Recommendation Report for Planning Permission for Works or Extension to a Dwelling

REF NO: FG/152/21/HH

LOCATION: 1 Upper West Drive
Ferring
BN12 5RB

PROPOSAL: Proposed two storey side extension

PROPOSED EAST ELEVATION 1:100

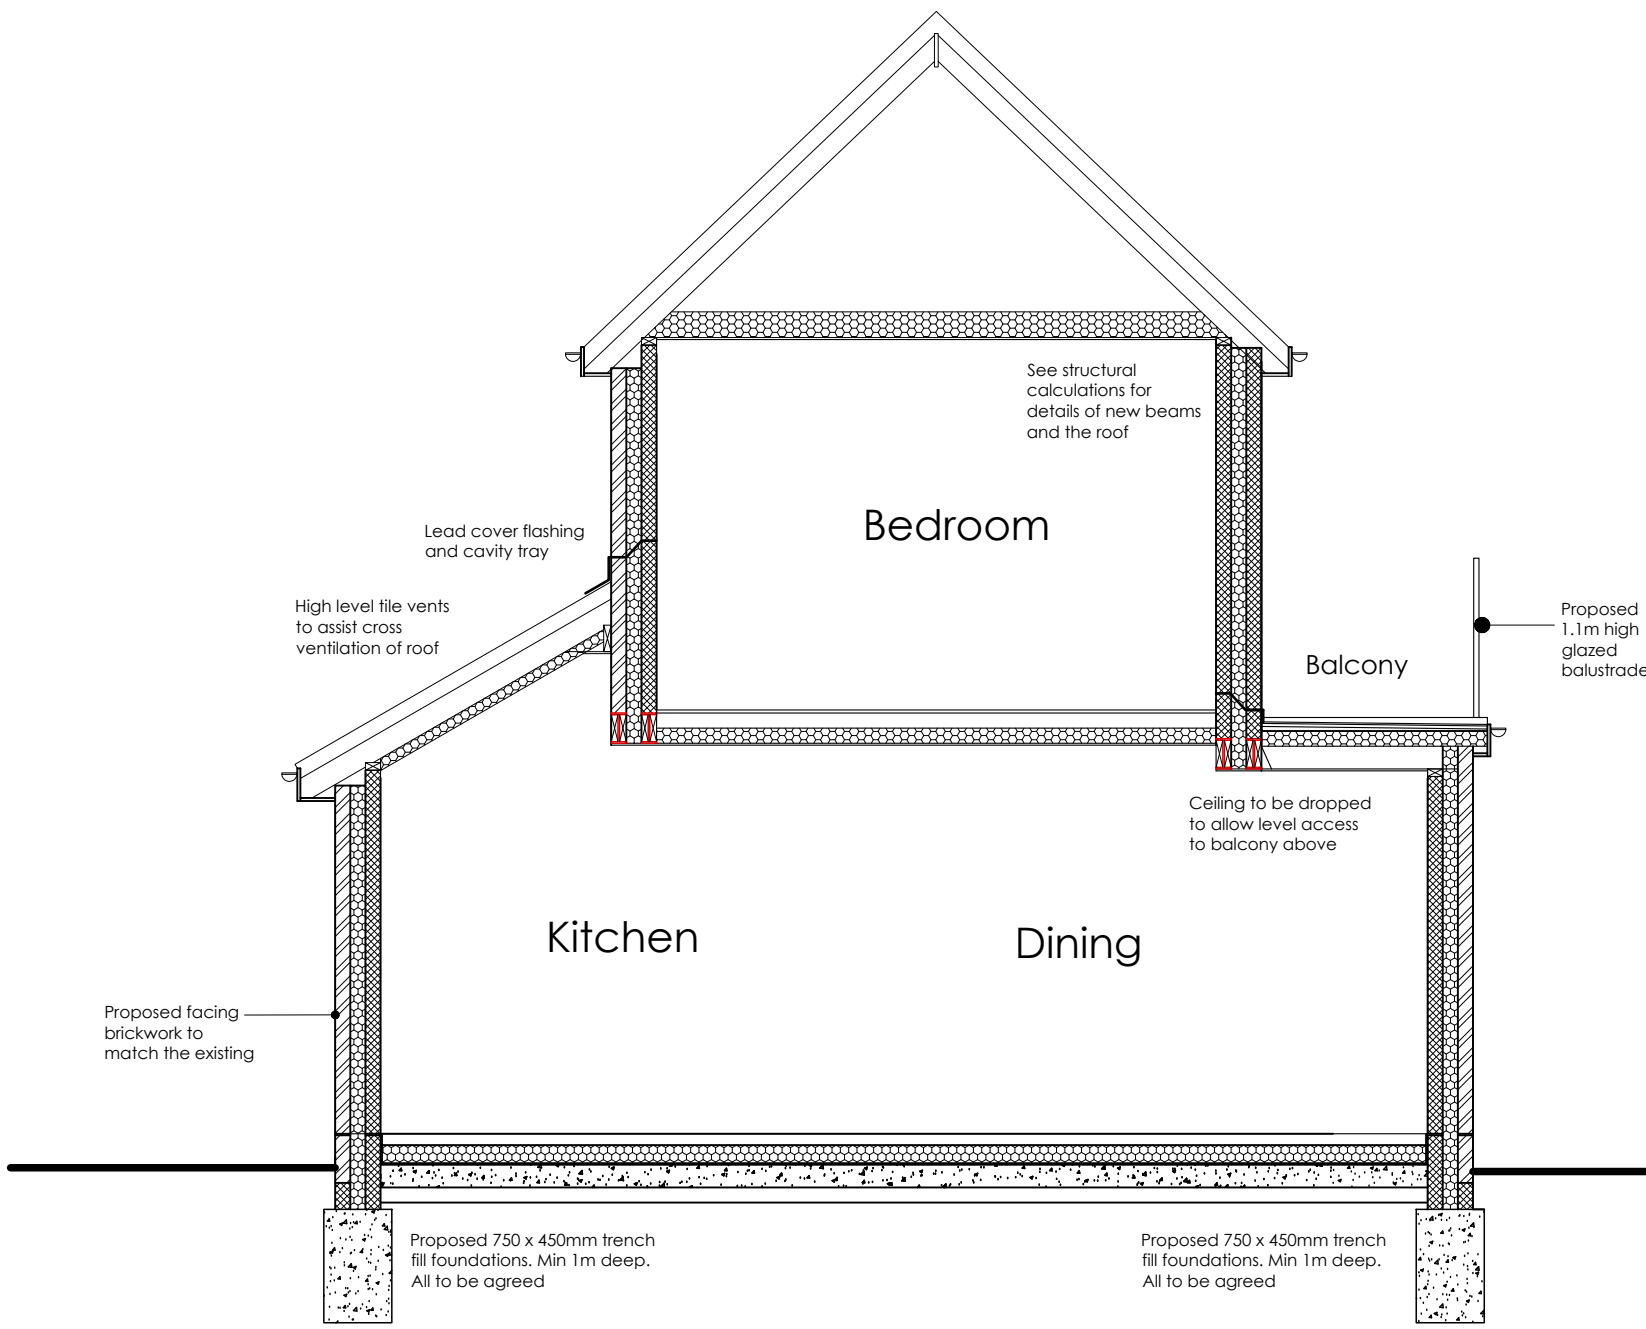
Due to around 2.20m retained to the rear (west) boundary there is increased risk to overshadowing or overbearing effects to neighbouring property number 1 Ferringham Way to west. However a gap of around 3.51m remaining to neighbouring property reduces impact of overshadowing. Also due to the design of the proposals at first floor being narrower footprint than at ground floor there is further distance to neighbouring property at first floor so is acceptable.

A 1.7m high obscured screen will be conditioned to be constructed to the first floor balcony to west parapet wall to prevent adverse overlooking effects to neighbouring property number 1 to west.
